NARROMINE SHIRE COUNCIL

19 December 2011

**RE: Submission in response to the EA on the proposed Tomingley Gold Mine
(Major Project Application Number PA 09_0155)**

Figure 2.1
MINE SITE LAYOUT

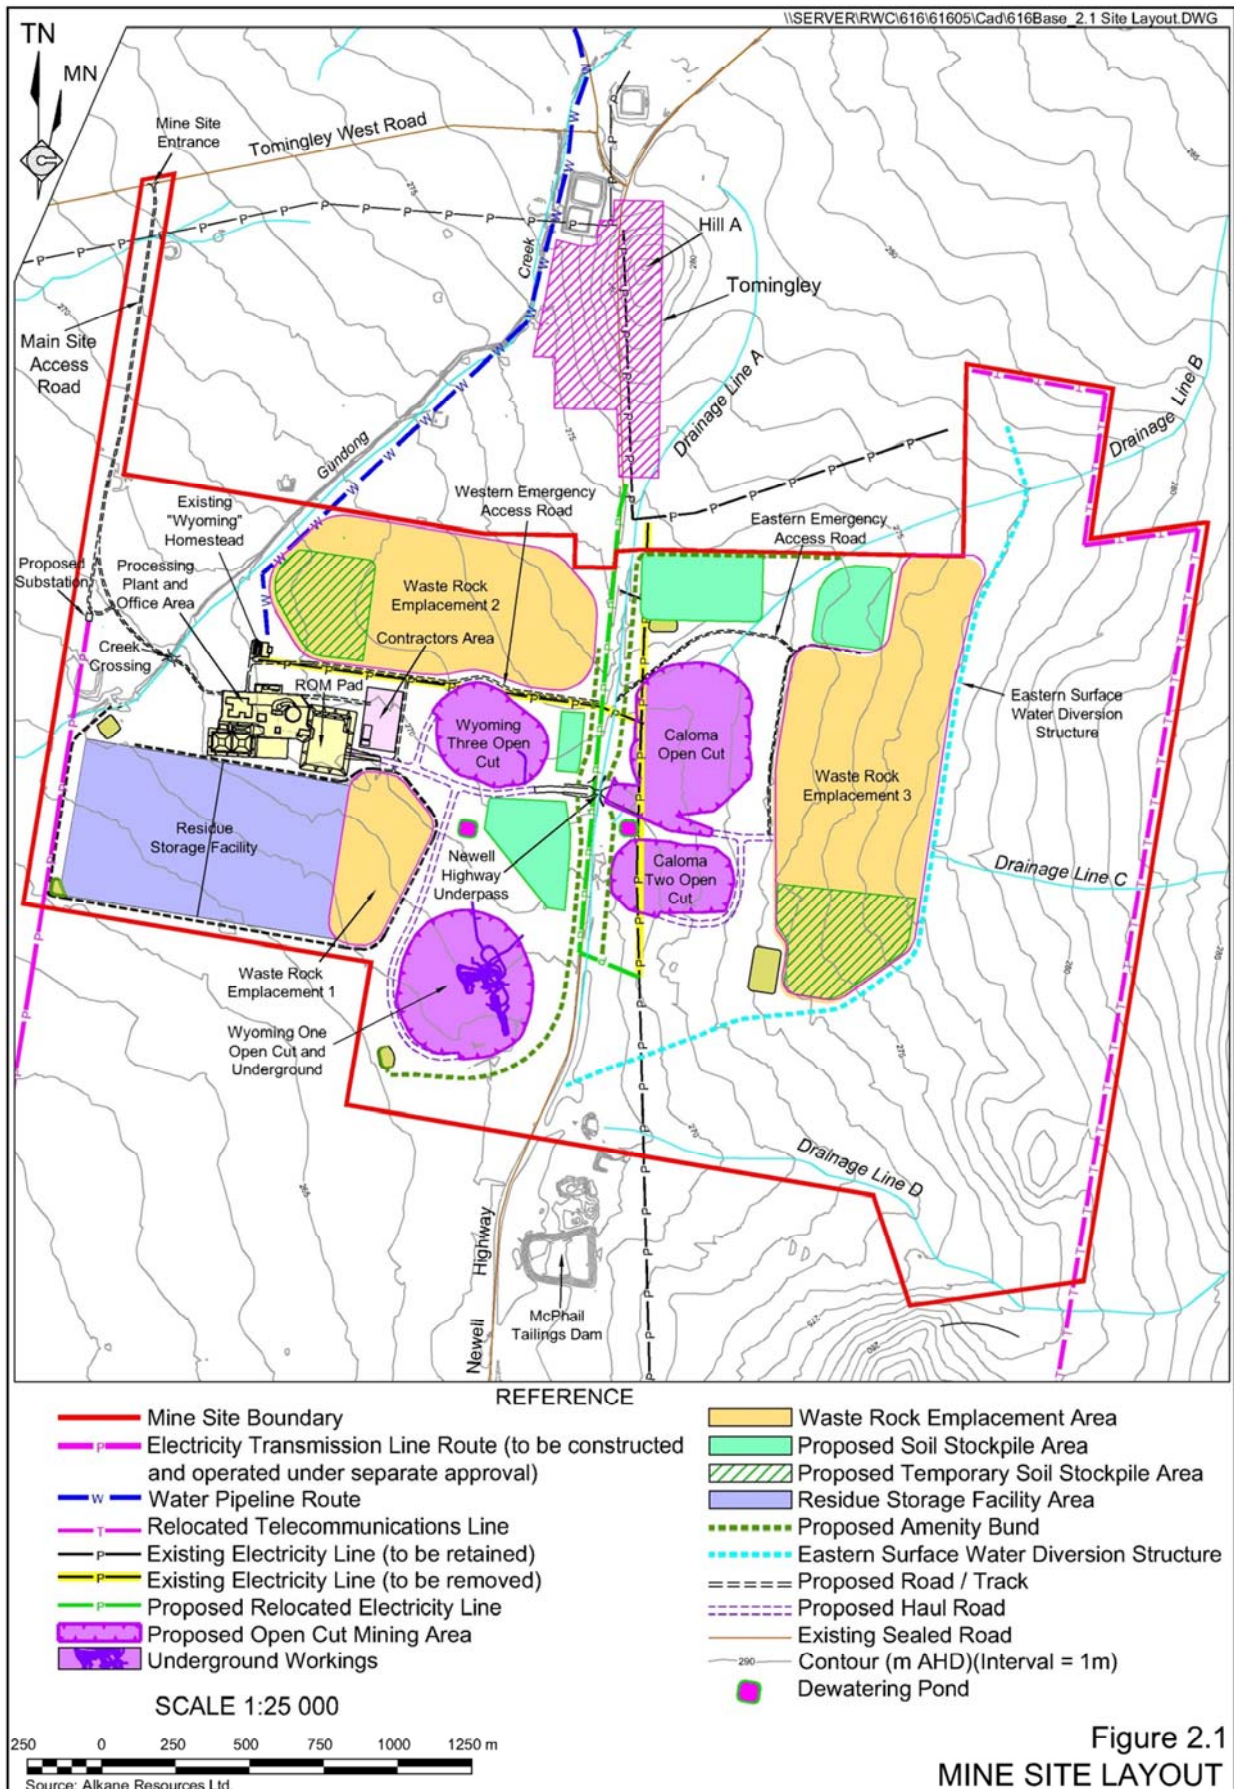
Figure 2.1 shows the Eastern Surface Water Diversion Structure appearing to catch and transfer water from a large catchment area to a discharge point adjacent to the

Newell Highway. Council seeks advice as to the discharge arrangements for this water and its possible impact on the Newell Highway (eg culvert capacity, flow paths, etc)
